Mr John Riordan
Planning Manager
LENDLEASE (MILLERS POINT) PTY LIMITED
COMMERCIAL TOWER 3 300
BARANGAROO AVENUE
BARANGAROO NSW 2000

**Barangaroo - R4A Residential Building (SSD-6964-Mod-3)
Request for Additional Information**

## R4A SIGNAGE ZONE NORTH - WEST ELEVATION

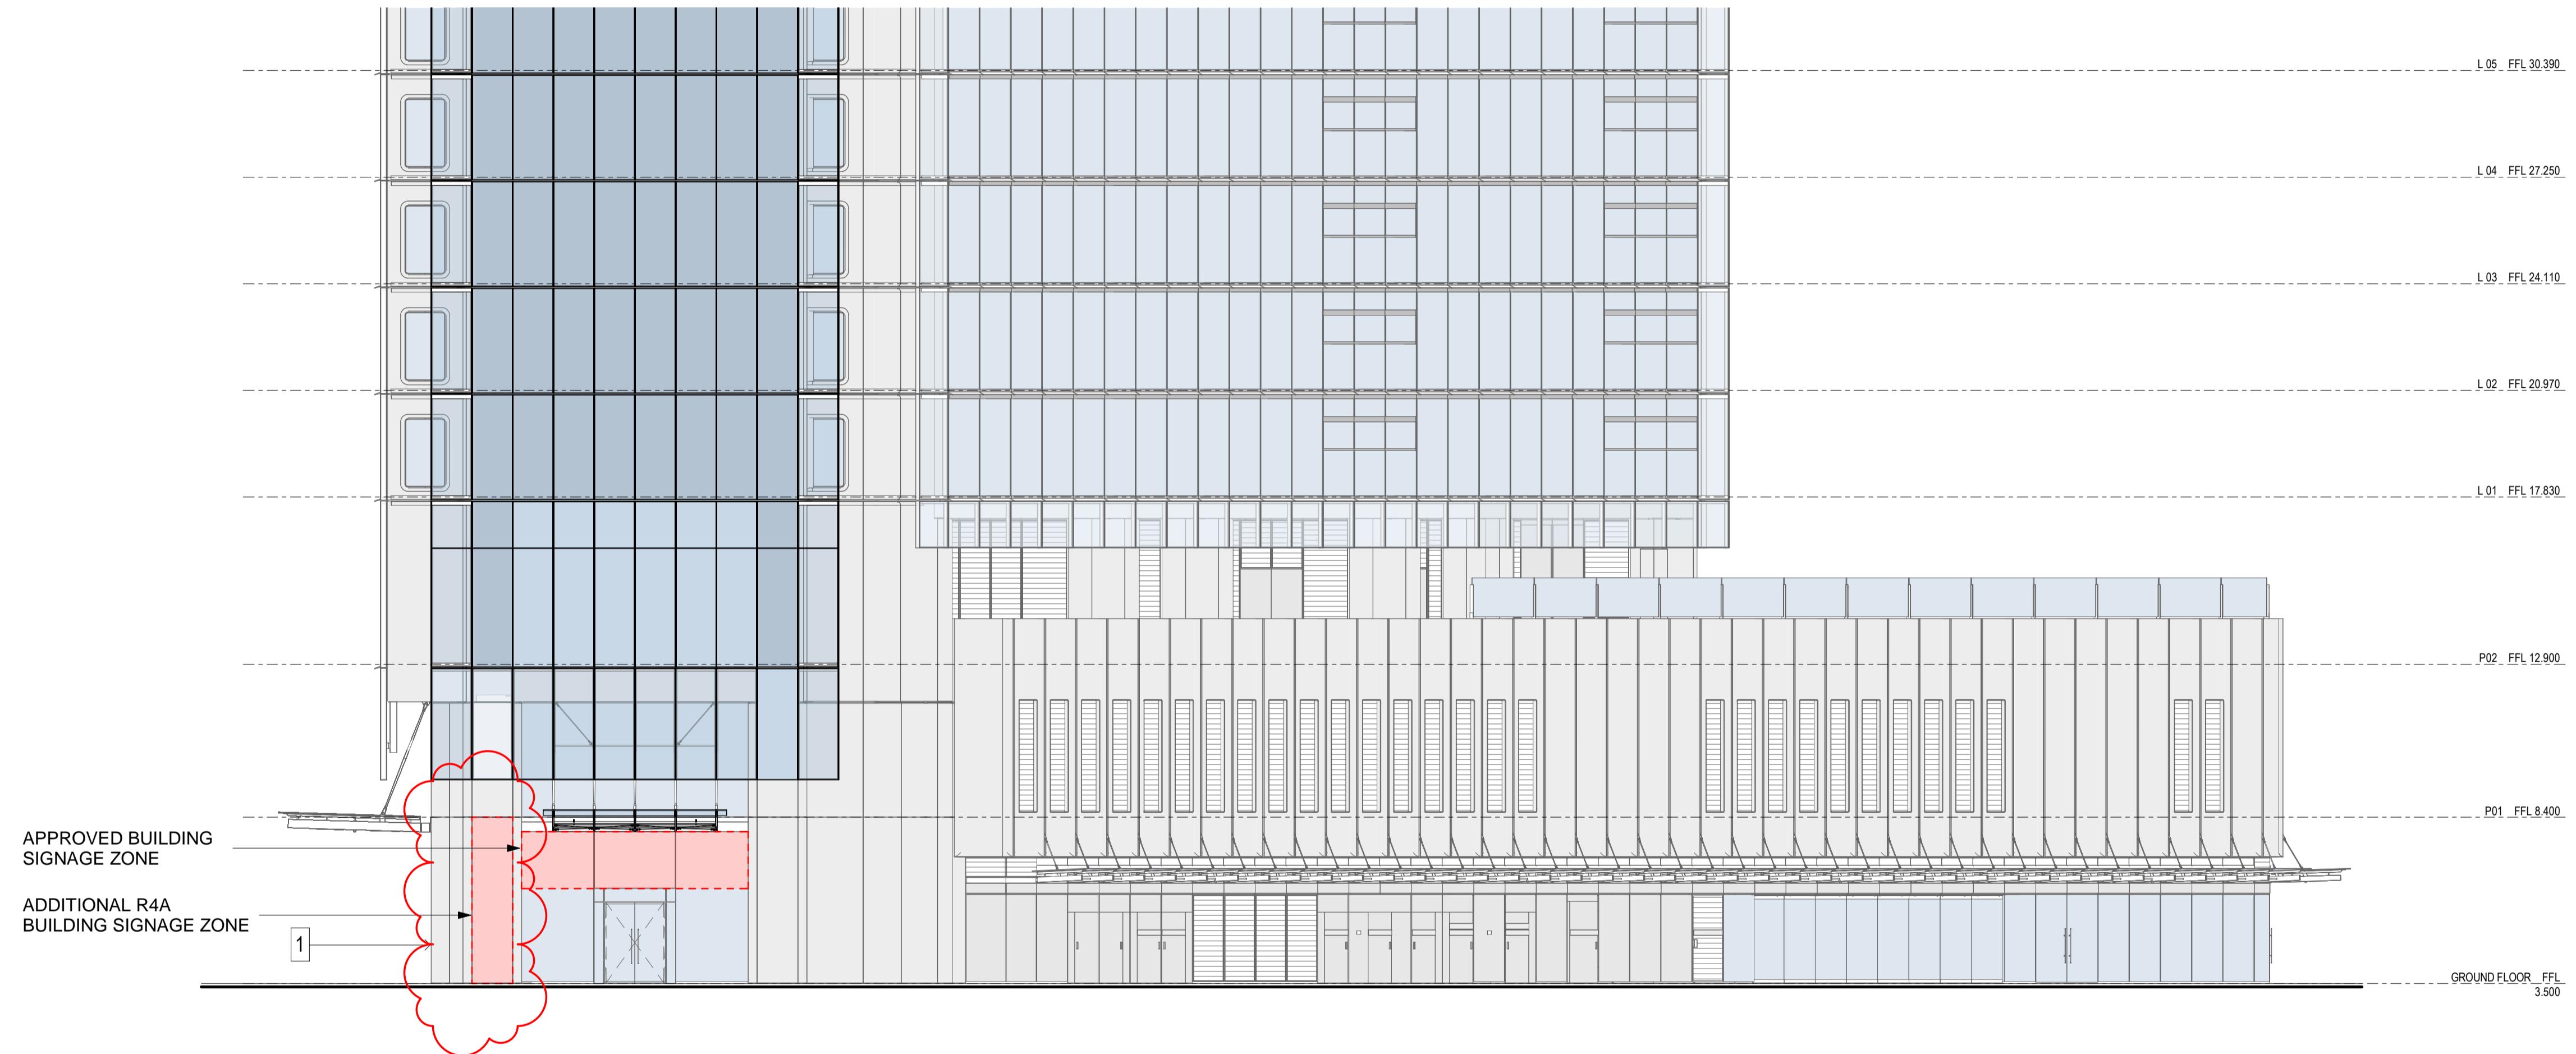
- An additional signage zone is sought at ground floor level, however the Department notes the Concept Plan Urban Design Controls (Control 9) specify that building identification signage is to be limited to one sign per frontage. You are therefore requested to demonstrate how the proposed signage zone is consistent with the concept approval or alternatively, remove it from the application.
- With respect to the revised cycle parking/residential storage, please also clarify:
 - the number of cycle parking spaces/storage facilities sought as part of the modification, noting there are currently 327 cycle parking spaces required under condition B23. The number of spaces should be annotated on plan for clarity.
 - the size of the existing cycle parking /storage facilities sought to be amended.
